MARINE RESTORATION & CONSTRUCTION LLC

Re: SHL22-006-SUB3-PLANS-042122_review, 9843 SE 42nd Place

We received *SHL22-006-SUB3-PLANS-042122_review.pdf* dated May 17, 2022. We have addressed all three comments in the section below.

PROPOSED PLAN VIEW
 SCALE: 1" = 20'

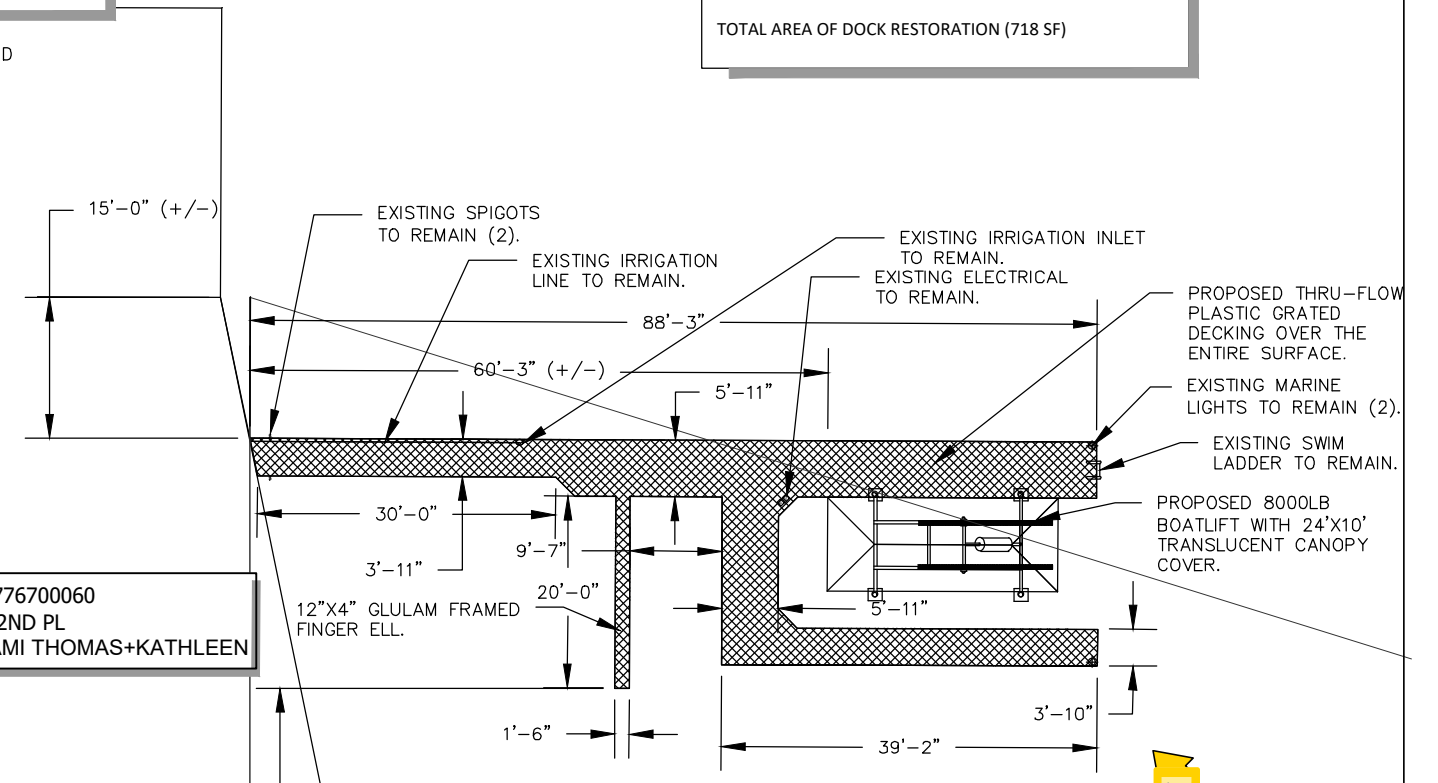
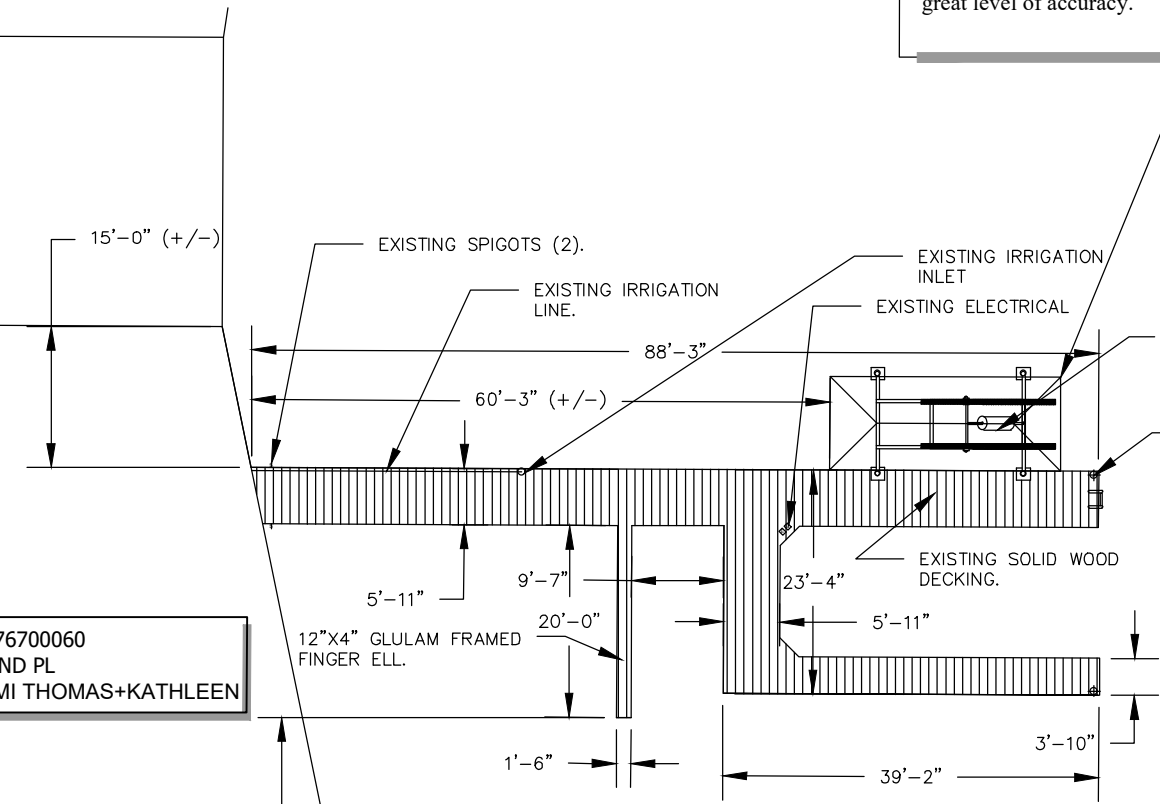
2. Page 3: Show lateral line setback per MICC 19.13.050(D) Table D.

3. Page 3: Provide surface area coverage of the moorage facility per MICC 19.13.050(F)(1).

Lateral line setback per MICC 19.13.050(D) Table D has been added to page 3 of the revised plan set, dated May 19, 2022.

The proposed moorage cover area per MICC 19.13.050(F)(1) 240 SF. This has been updated on page 3 of the revised plan set, dated May 19, 2022.
